Drafted 30 December 2011

**Planning Application, Ribble Valley District
3/11/0939 Otter House, 9 Mitton Road, Whalley**

Drawing Title
Proposed plan, elevations and block plan

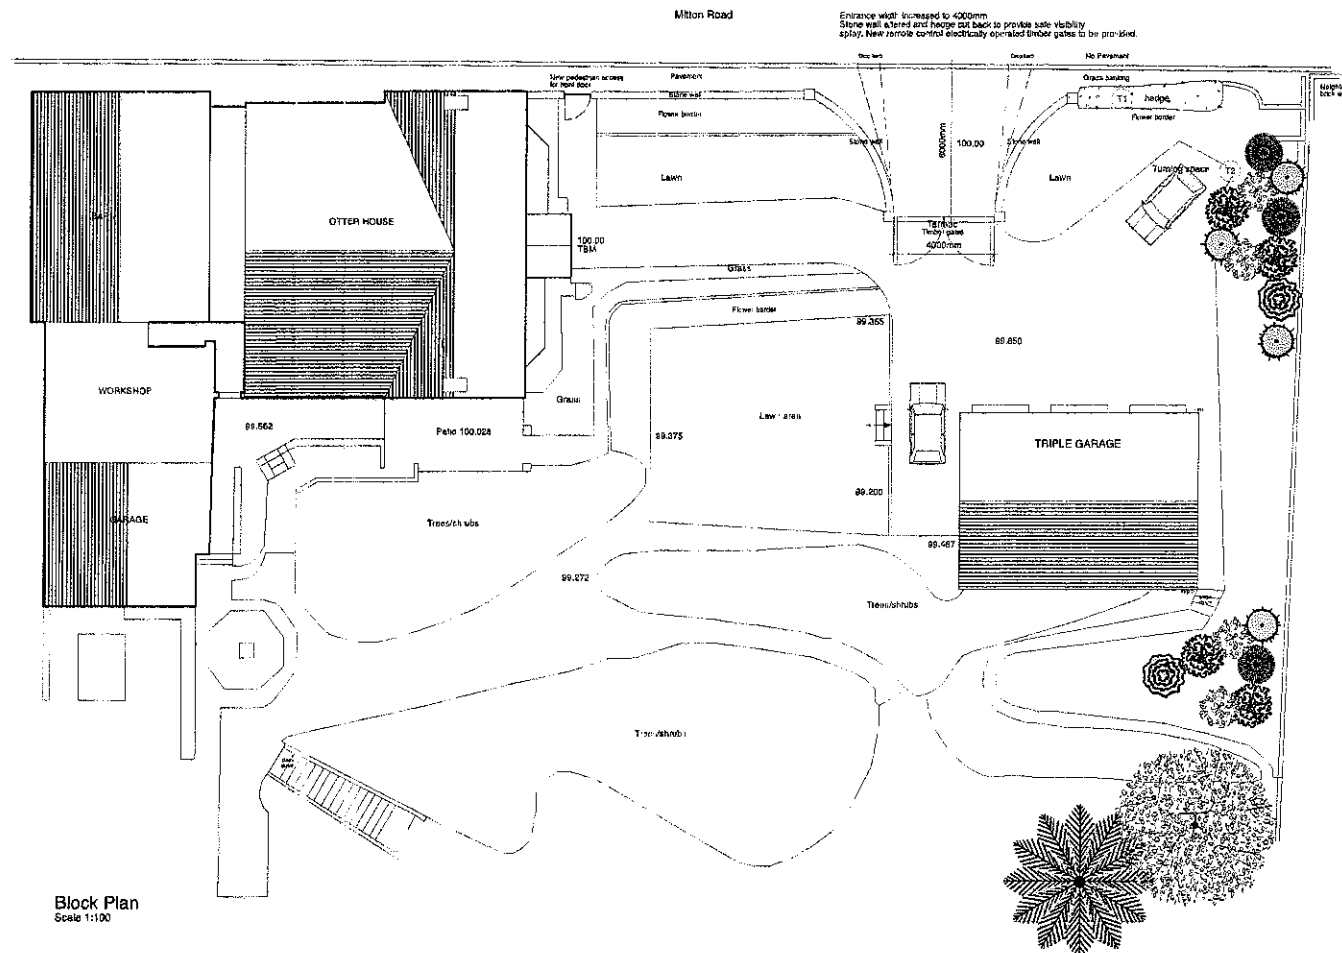
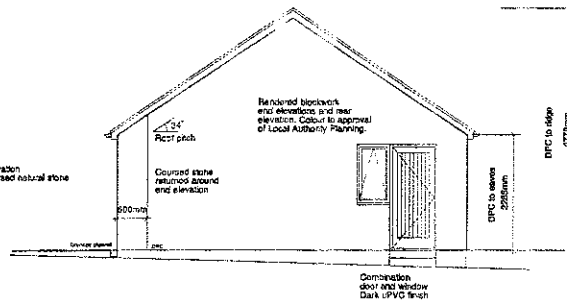
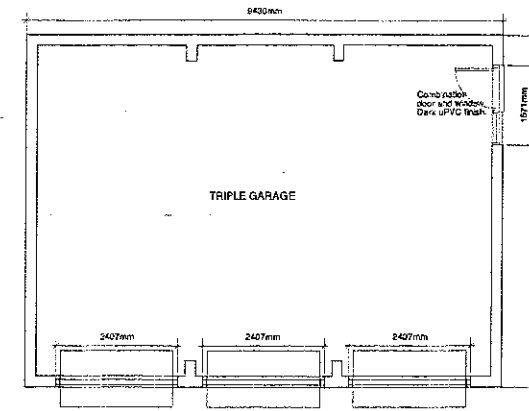
While I welcome the proposed access improvements there is no indication of the sightlines that will be secured as a result of these changes. In view of the highway characteristics at this location, I would recommend a minimal visibility splay of 40m in either direction, to be measured from 2.0m back from the edge of carriageway. The inclusion of the relevant dimensions on an amended site plan would be satisfactory.
